Application no: H16/1201/98

Description: Glass doors to entrance of
White Hart Hotel

Location: White Hart Hotel
Market Place
Spalding
Lincs

Amendment: Relocation of rear glass screens to allow retention of
more of the historic structure. Dwg. No. 6708/G/10 & 11B

6708/G/10 SCALE 1:20 OCT. 98.

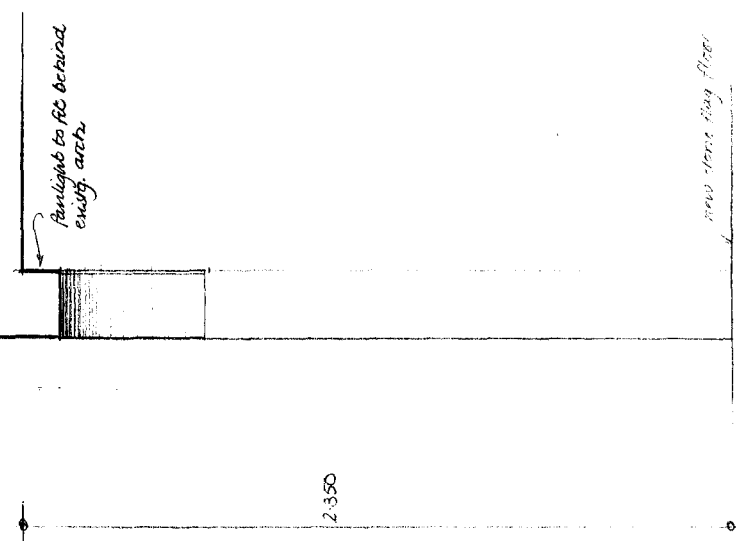
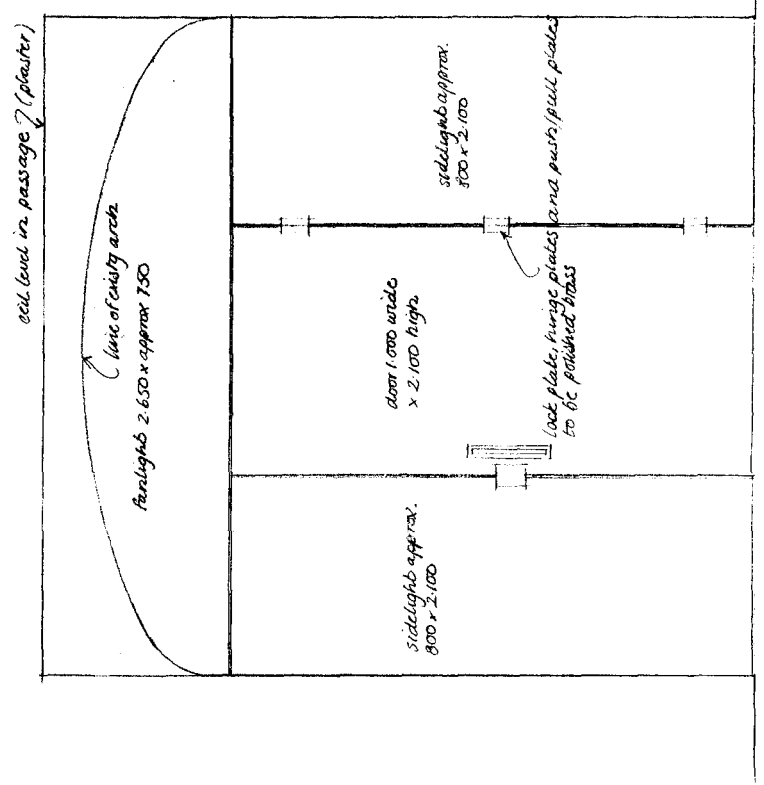
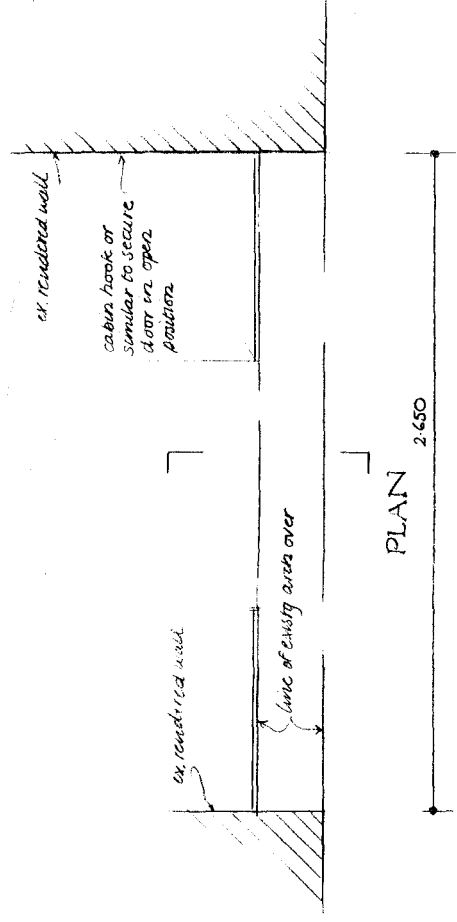
RELOCATION OF REAR GLASS SCREENS
TO ALLOW THE RETENTION OF MORE
OF THE HISTORIC STRUCTURE
